**KIRKLEES METROPOLITAN COUNCIL
INVESTMENT & REGENERATION SERVICE**

DELEGATED DECISION TO DETERMINE PLANNING APPLICATIONS

Reference No:	2025/62/91249/W
Site Address:	Royds Hall Printing, 96, Longwood Road, Paddock, Huddersfield, HD3 4EJ
Description:	Change of use of existing retail unit (Class E(a)) to form 3 bedsits at first floor level with entrance lobby at ground floor level including associated works.
Recommending Officer:	Kerri Simpson

Officer Report – 2025/91249

Drawing title  
**Plans and Elevation  
as Proposed**

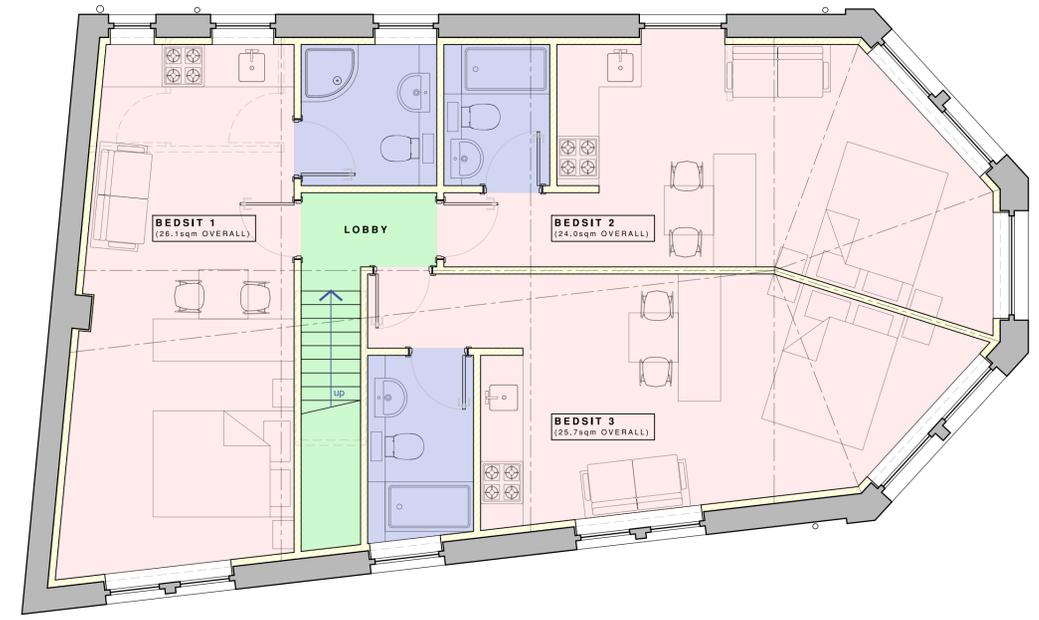
The proposed external alterations are limited to the south elevation (adjacent Longwood Road) and include the insertion of a new entrance door and side glazing panel to create a dedicated residential entrance lobby, along with the formation of a low level timber clad enclosure to house bin and cycle storage. All other elevations remain unchanged.

The design of the new entrance would be modest and in keeping with the commercial appearance of the building, while the timber store would be low in height and located adjacent the shared boundary with No's 1G and 1H Quarmby Road, minimising visual prominence. The proposed works are not considered to result in harm to the visual amenity of the street scene or the character of the area.

While it is acknowledged the proposal seeks "bedsits", they would be entirely self-contained with no shared primary facilities; therefore, are to be assessed as fully self-contained residential units each comprising an open-plan living arrangement and a separate shower room. The submitted floor plans indicate that the gross internal areas of the proposed units would range from circa 24sqm to 26sqm. In accordance with the Nationally Described Space Standards (NDSS) 2015, a minimum of 37sqm is required for a single storey, 1 person self-contained dwelling with a shower room. As such, the proposal would fall significantly short of the NDSS requirements resulting in a constrained sleeping, living, cooking areas and a lack of built-in storage space. Furthermore, the units would not have access to private or communal outdoor amenity space nor has the application provided any justification for the lack of provision.

The development would therefore provide a poor standard of accommodation for future occupiers and is considered contrary to Principles 16 and 17 of the Housebuilders Design Guide SPD and Policy LP24 of the Kirklees Local Plan.

The proposed development would introduce three new self-contained units at first floor level, with habitable room windows facing directly onto the front elevation of residential properties on the opposite side of Longwood Road. The distance between the south elevation of the application building and these neighbouring properties is approximately 18m, measured elevation to elevation.

According to the Kirklees Housebuilders Design Guide SPD, a minimum distance of 21 meters is generally required between opposing habitable room windows to maintain adequate levels of privacy between dwellings. The proposed separation falls short of this guidance, and no suitable mitigation has been put forward. It is therefore considered that the proposal would result in a substandard relationship between residential properties, resulting in mutual overlooking and reduced privacy for both future and existing occupiers.

The proposed development would fail to provide an adequate standard of accommodation for future occupiers due to significantly substandard internal floor areas below nationally described space standards and a lack of outdoor space for future occupants. Additionally, the 18m separation between the proposed habitable room windows and those of existing dwellings on Longwood Road falls short of the minimum requirements set out in the Housebuilders Design Guide SPD, resulting in an unacceptable level of overlooking and loss of privacy. The proposal is therefore contrary to Principles 6, 16 and 17 of the Housebuilders Design Guide SPD, Policy LP24 of the Kirklees Local Plan and Chapter 12 of the National Planning Policy Framework.

The proposal includes no off-street parking provision for future residents and is not accompanied by a transport statement or justification for a car-free scheme. While secure cycle storage is proposed and the site lines within walking distance of a local shop and nearby bus stops, the bus services is limited to an hourly frequency. The site is not located within a defined town or local centre, and essential services such as supermarkets and healthcare facilities are not within realistic walking distance. As such, the site is not considered to be in a highly sustainable location, and there would likely be a significant reliance on private car use.

In the absence of any on-site car parking provision or supporting evidence to demonstrate that future occupiers would not contribute to increased demand for on-street parking, the proposal is considered unacceptable. It would risk contributing to parking stress in the surrounding area and would fail to promote a balanced and sustainable approach to development. It would therefore be contrary to Policy LP21 and LP22 of the Kirklees Local Plan, the Highways Design Guide SPD, and Paragraph 116 of the National Planning Policy Framework 2024.

1. The proposed self-contained residential units would each have a gross internal area ranging from 24sqm to 26.1sqm, which falls significantly below the minimum 37sqm required for a 1 person, 1 bed, single storey dwelling with shower room, as set out in the Technical housing standards – nationally described space standard (March 2015). As a result, the development would fail to provide an acceptable standard of accommodation for future occupiers and is therefore contrary to Policies LP11 and LP24(a) of the Kirklees Local Plan, Principle 16 of

1. The proposed habitable room windows on the south elevation would be located approximately 18m from the front elevation of existing residential properties at No's 127 to 125 (Odds) Longwood Road. This falls short of the 21 metre minimum set out in the Councils adopted Housebuilders Design Guide SPD, leading to an unacceptable level of overlooking and loss of privacy for both existing and future occupiers. The proposal therefore contrary to Principle 6 of the Housebuilders Design Guide SPD, Policy LP24 of the Kirklees Local Plan and Chapter 12, Paragraph 135(f) of the National Planning Policy Framework 2024.

2. The proposal fails to provide any off-street parking for future occupiers. The site is located in a moderately sustainable location with limited public transport and limited access to key amenities. No transport statement or justification has been provided to support a car-free development. The proposal is therefore likely to result in increased demand in on-street parking to the detriment of local highway safety and amenity, contrary to Policy LP21 and LP21 of the Kirklees Local Plan, the Highways Design Guide SPD and Chapter 9, Paragraph 116 of the National Planning Policy Framework 2024.
